September 20, 2022

Subject: Forest Ridge (LPF-22-00006) Final Long Plat Ph 4 – Return of Application and Request for Additional Information

OPEN SPACE COMPLIANCE MAP

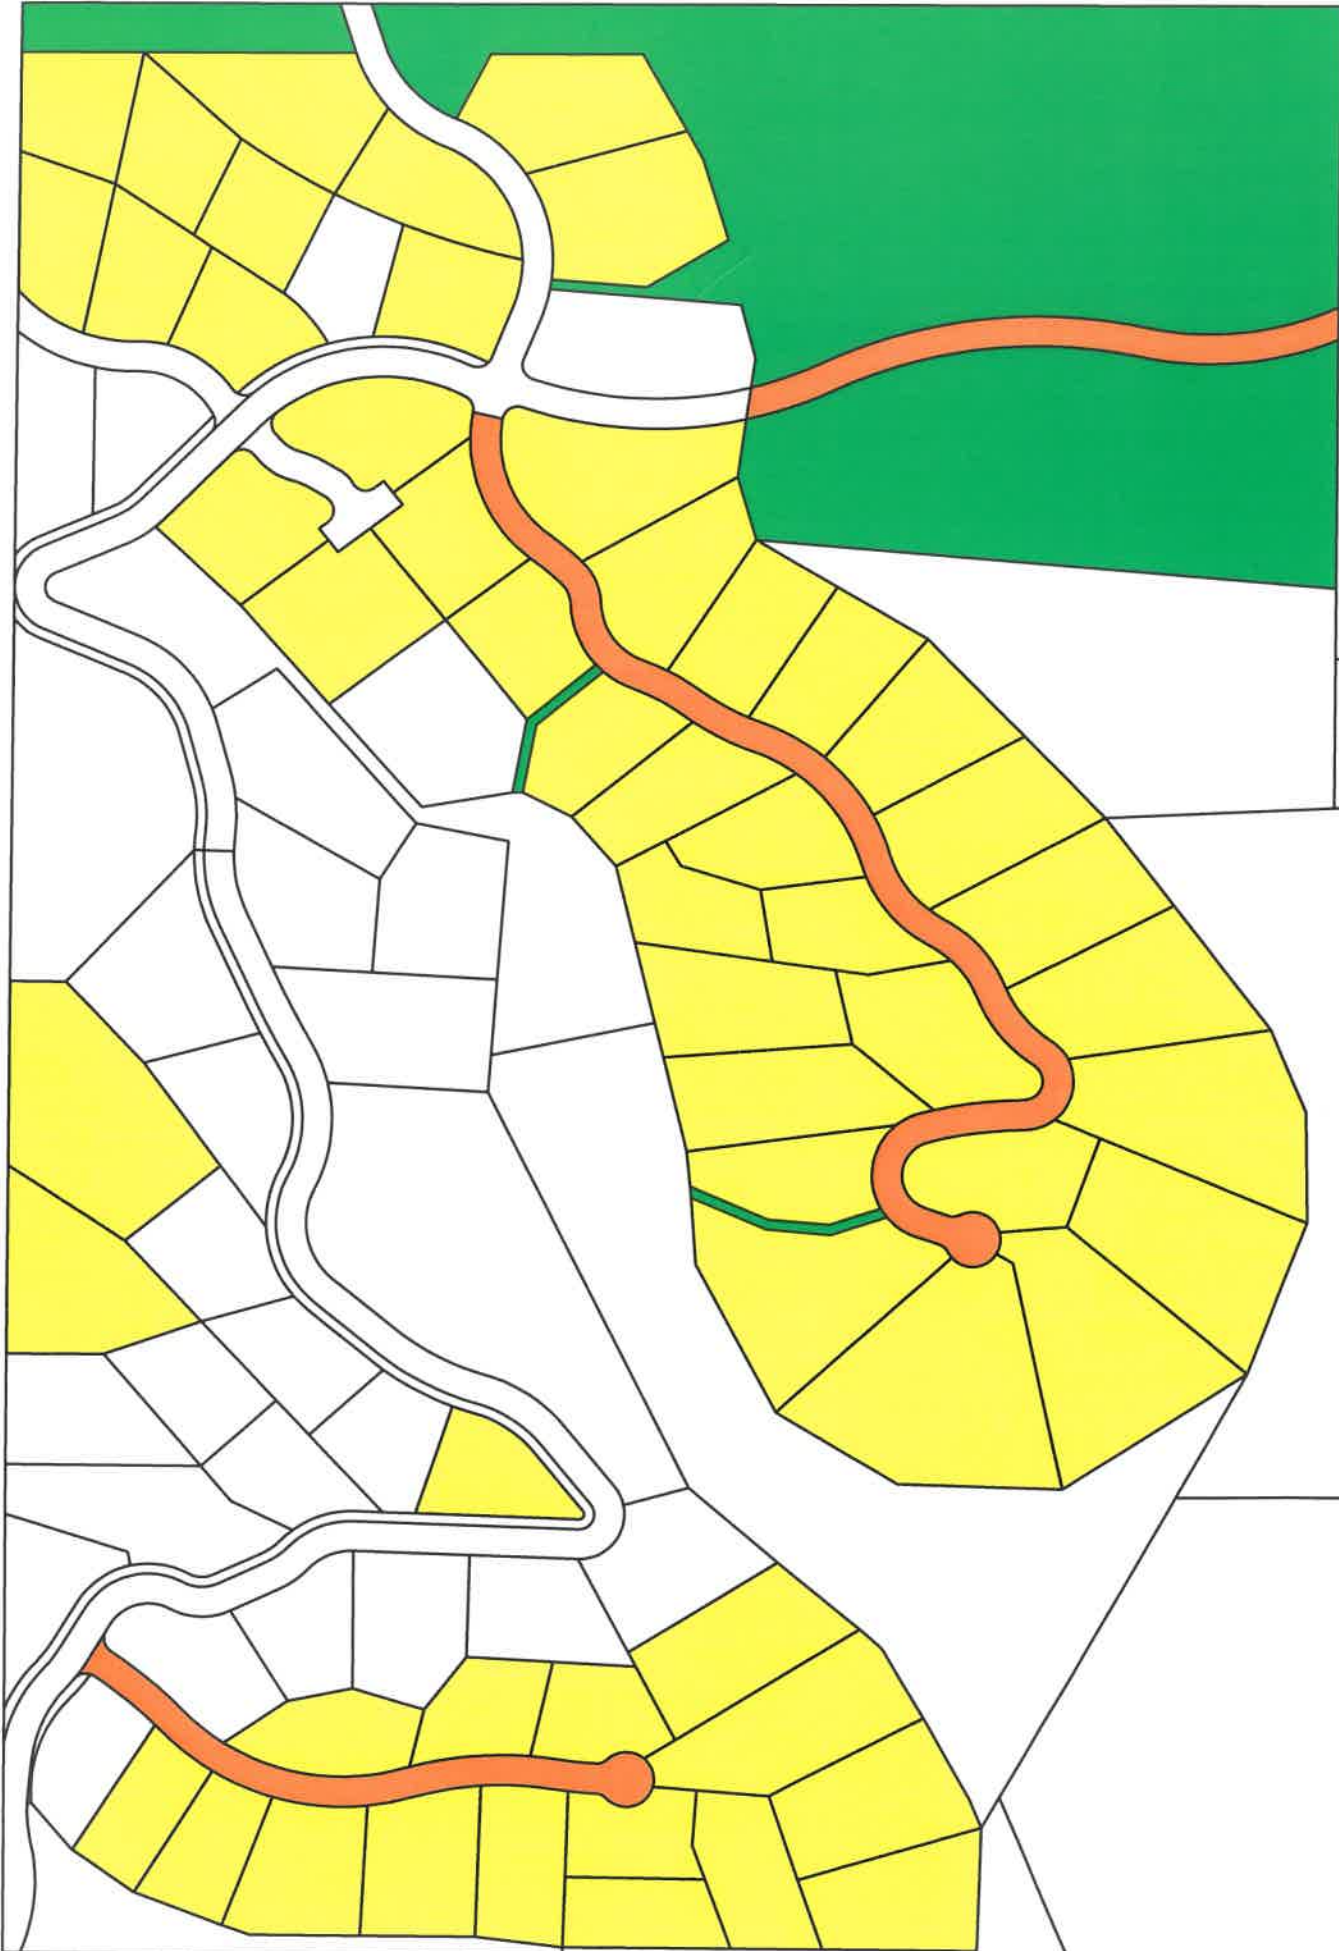
- Final mylars shall include the final plat number LPF-22-00006 in addition to the preliminary file number already provided.
- Please provide a copy of the latest CCR's that demonstrate open space tract ownership and maintenance.
- Please demonstrate and show calculations that the open space proposed does not include the Commercial Forest setback area, streams, wetlands and their associated buffers per condition 8 as it appears that some of these spaces are being used for open space.
- Please provide documentation for stream crossings from state departments for this phase.
- Please provide documentation/correspondence regarding fire flow requirements
- SEPA MDNS Conditions were not addressed in the compliance document at all other than “Applicant will comply”. Please address these conditions.
- Snow removal plan was submitted but has no indications on where snow is to be put/located at.
